**Consultation Response from KC,
Ecology Unit**

2021/93689 Land to the south of, Ravensthorpe Road / Lees Hall Road, Dewsbury

Responding Officer: Gareth Hey

WINTERING BIRD SURVEY RESULTS VISIT 1

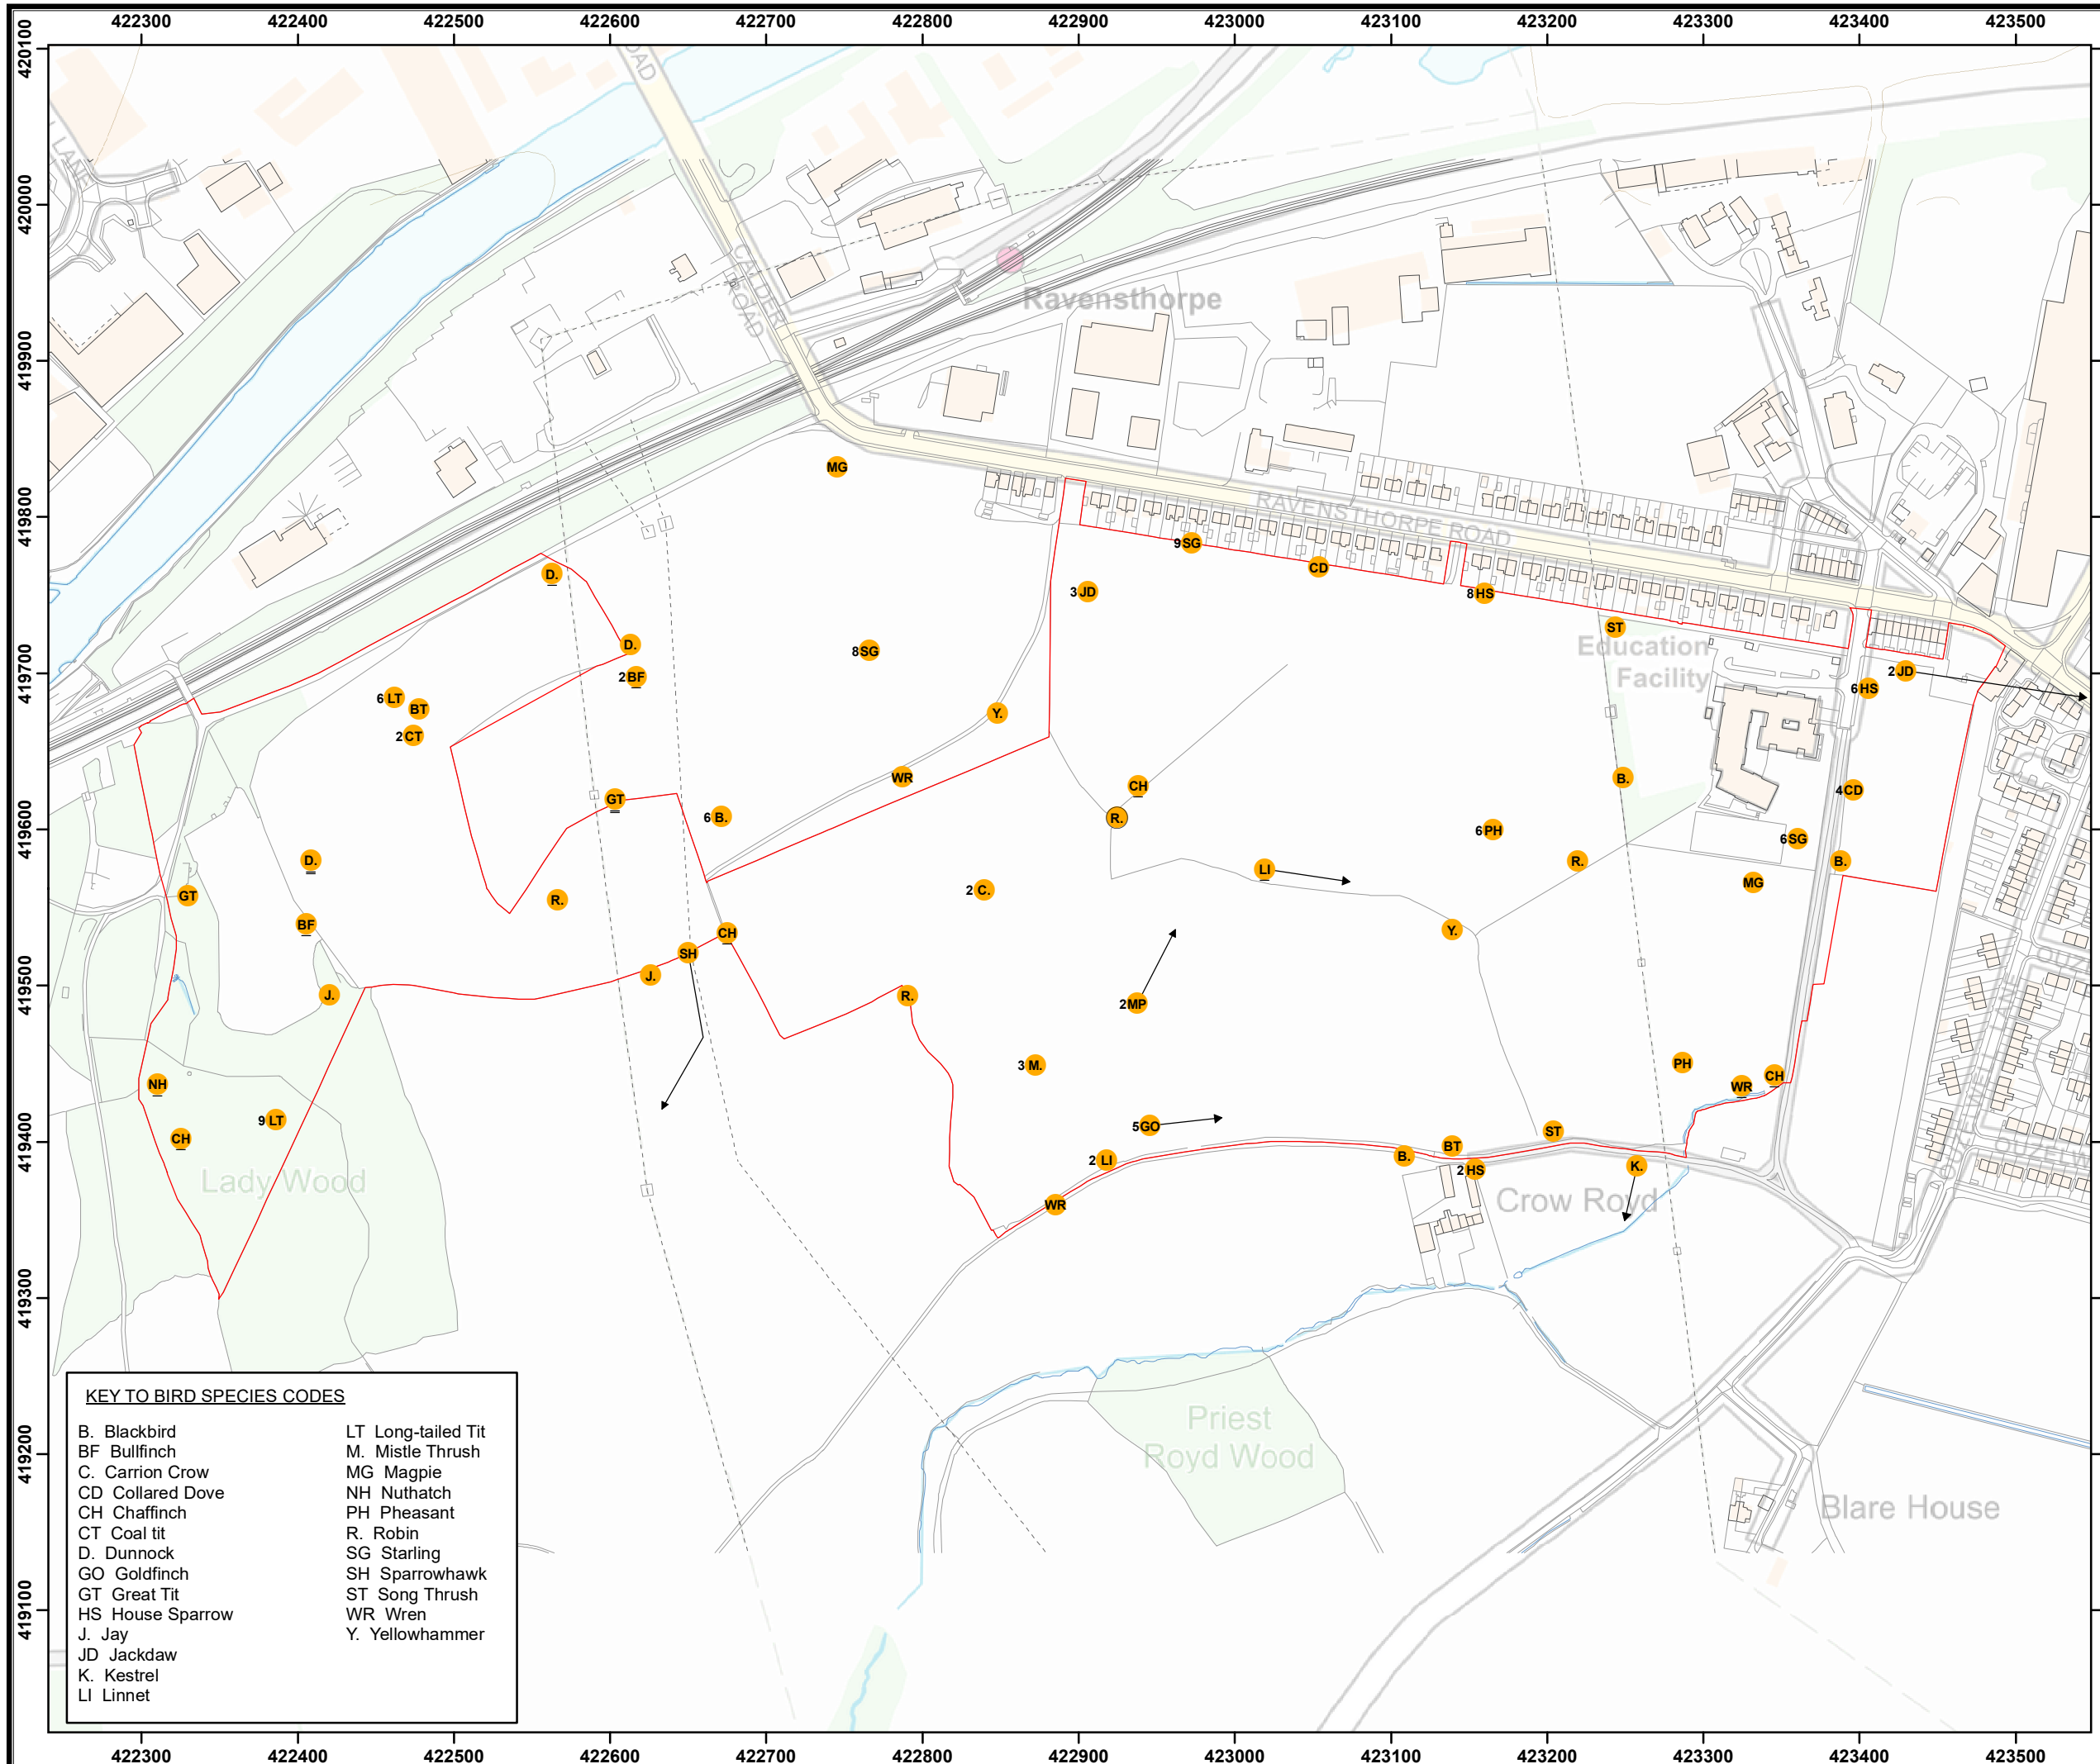
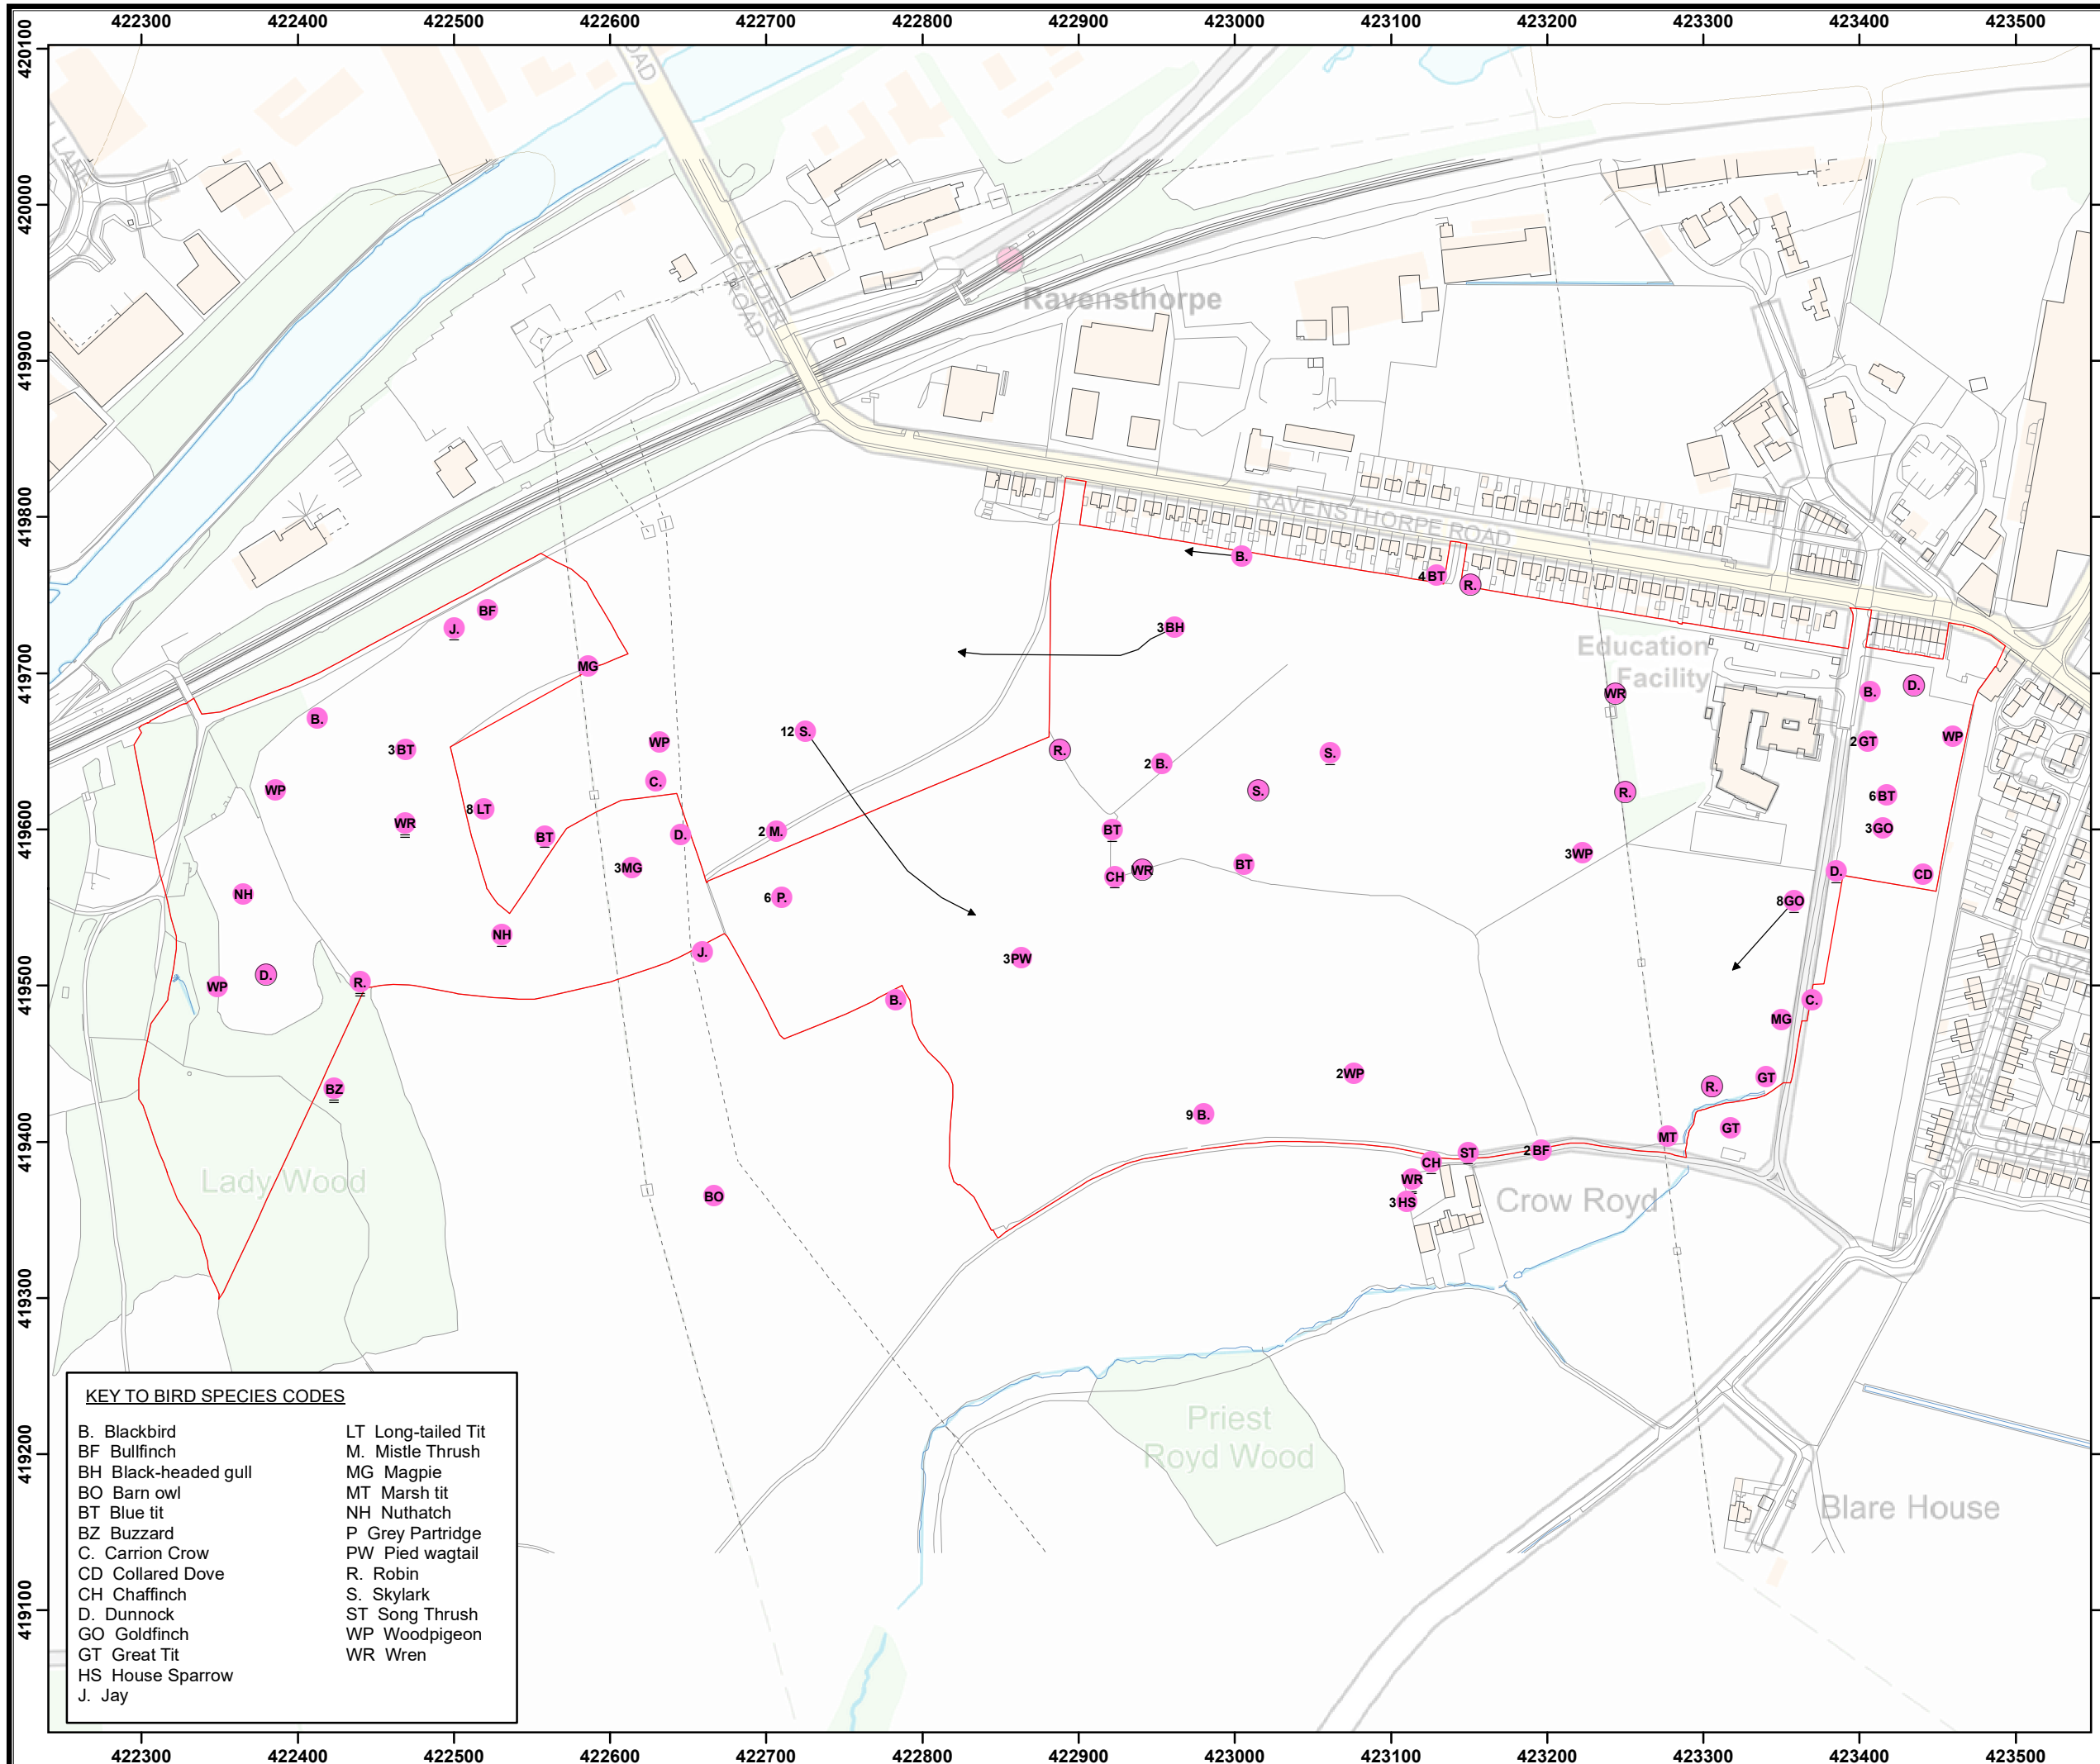
No information regarding wintering bird species has been provided as part of the EclA. Given the habitats present on site and connections to other areas of suitable habitats within the area, information relating to wintering bird species should be provided prior to determination.

- **Detailed roosting survey report including presence/absence surveys on buildings to be demolished for access.**
- **Badger survey report to be submitted including sett monitoring and territory analysis.**
- **Wintering bird survey information to be submitted to determine the sites suitability for wintering birds and if additional surveys are required.**
